REQUEST

Approximately 0.55 acres located south of Tuckaseegee Road and east of Enderly Road.

The petition proposes to allow expansion of a parking area to support uses permitted in the MUDD district in the adaptive reuse of a building in the Enderly Park neighborhood.

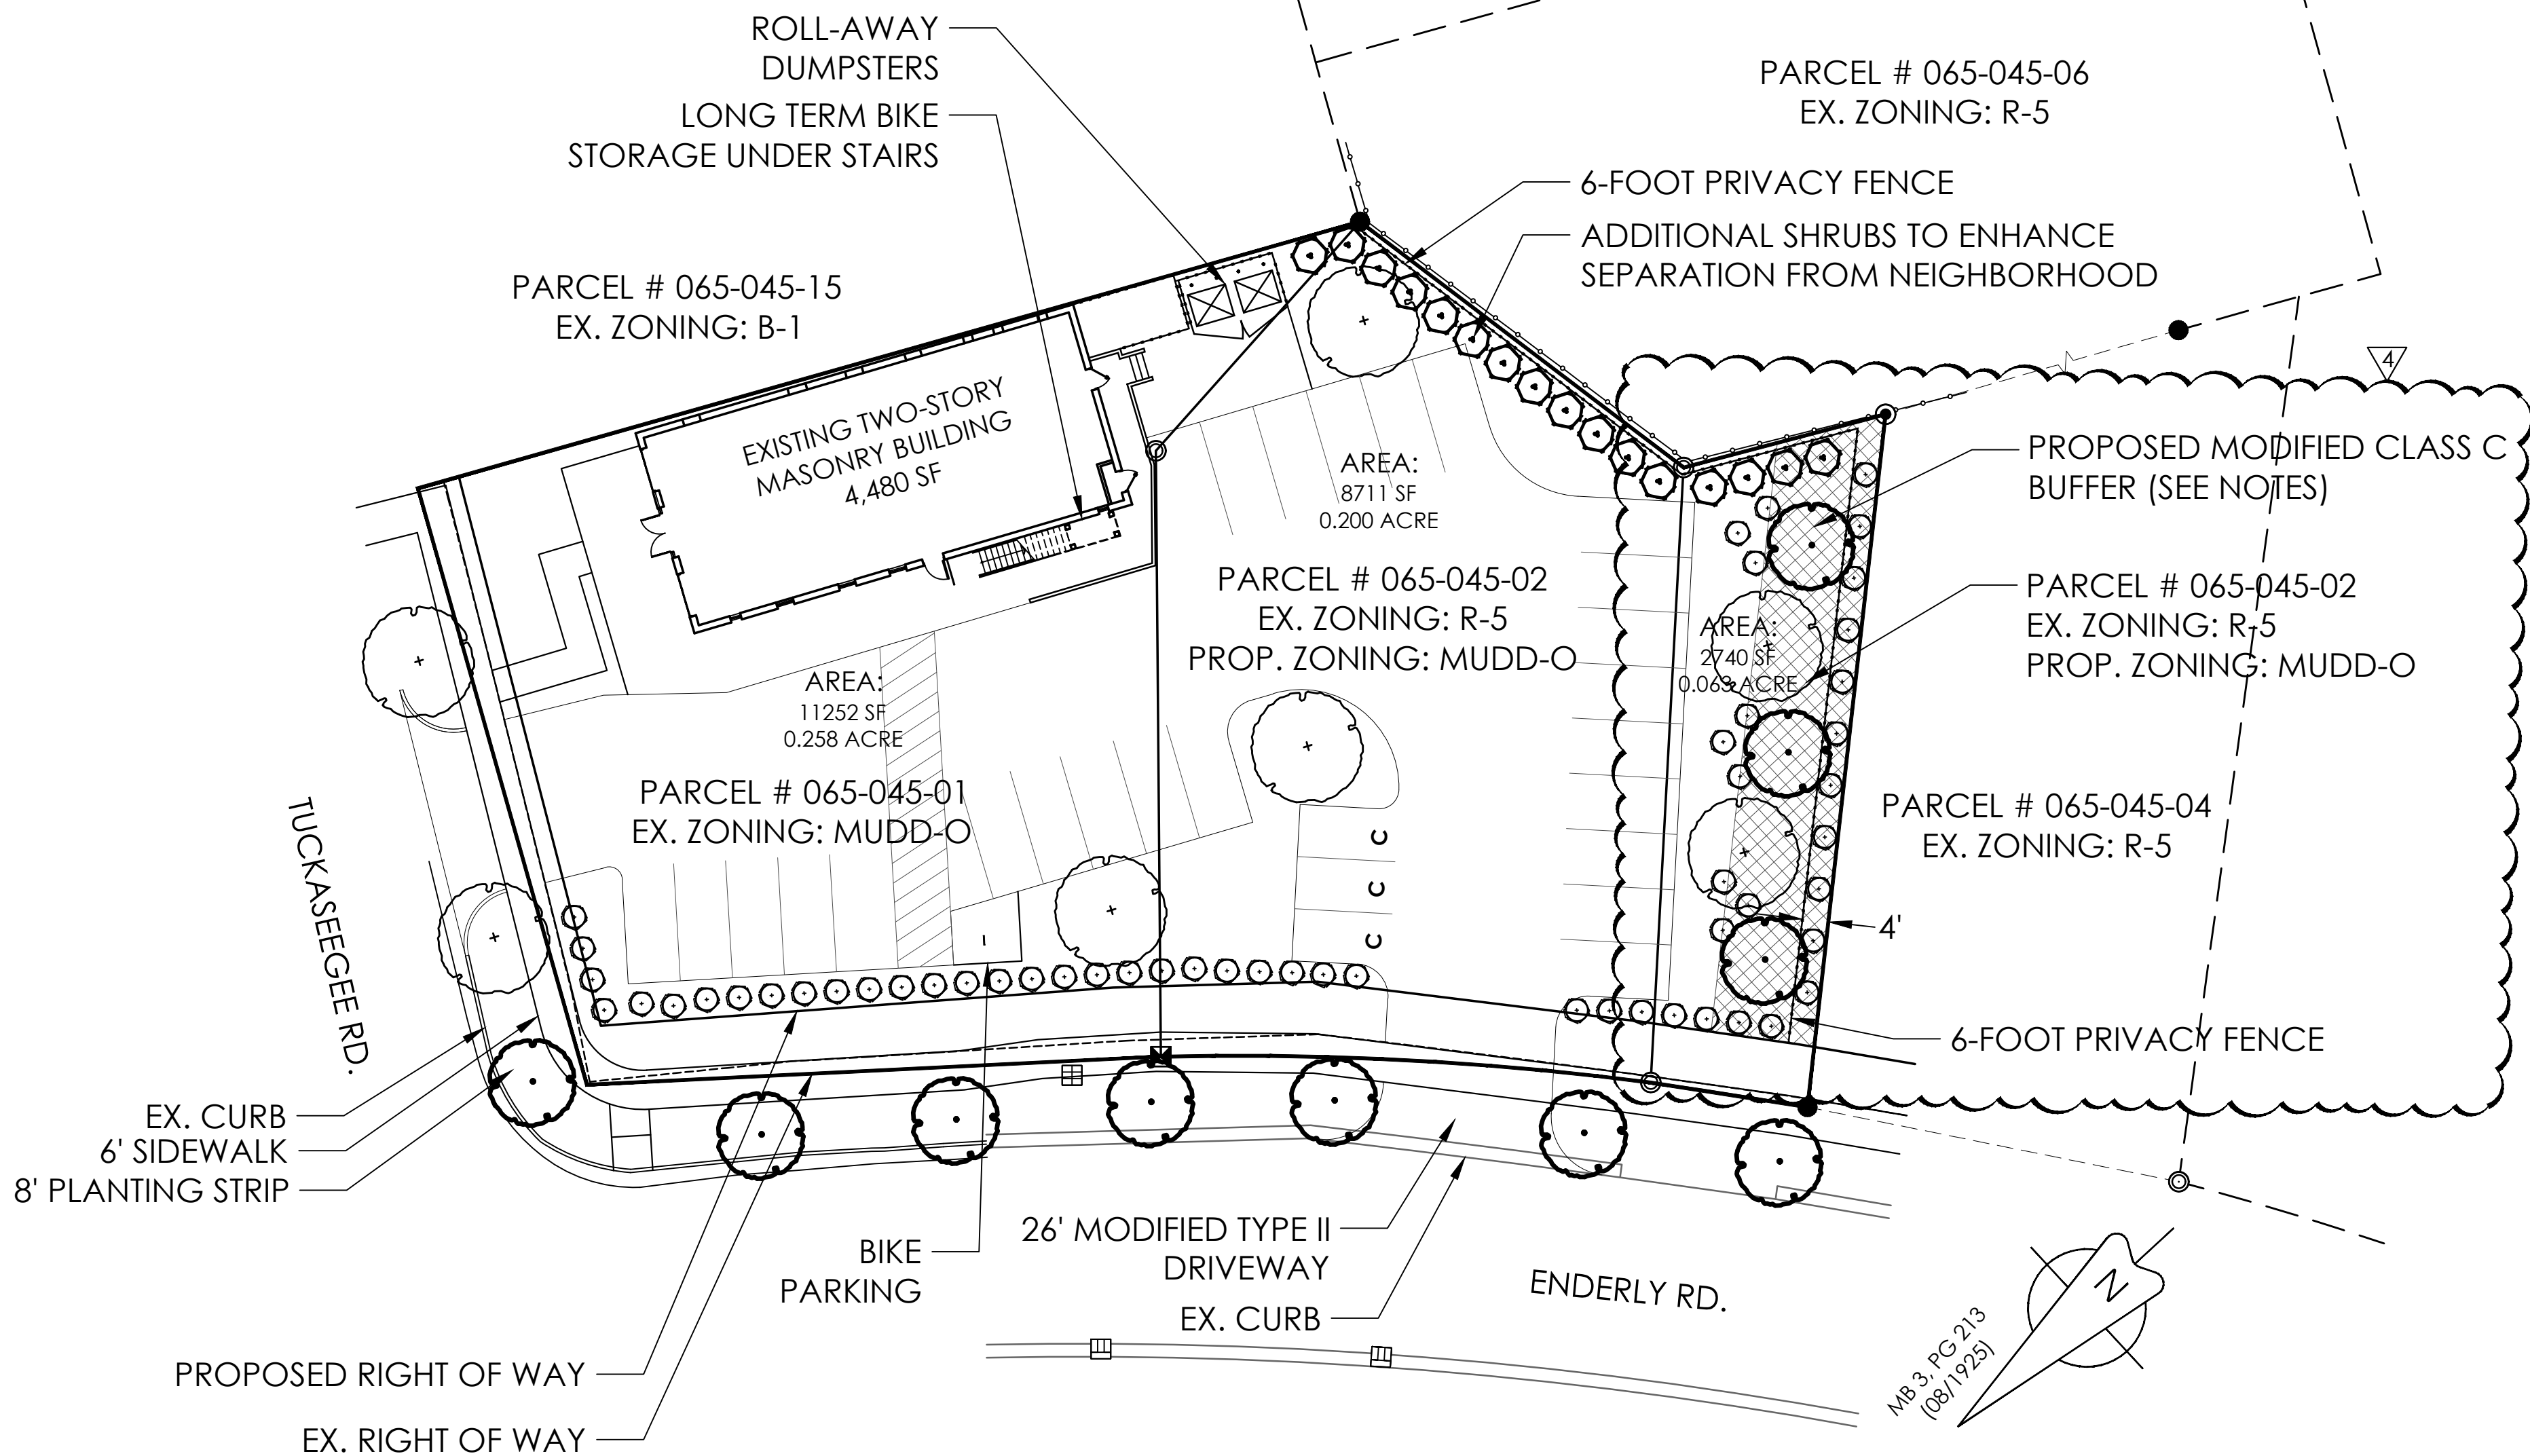
- ~~1. Add a conditional note stating that the existing two-story commercial structure will remain and not be expanded and that no other building may be constructed.~~ **ADDRESSED**
- ~~2. Clarify that note 2 under Optional Provisions applies only to the existing two-story commercial structure.~~ **ADDRESSED**
- ~~3. Remove note 3 under Optional Provisions.~~ **ADDRESSED**
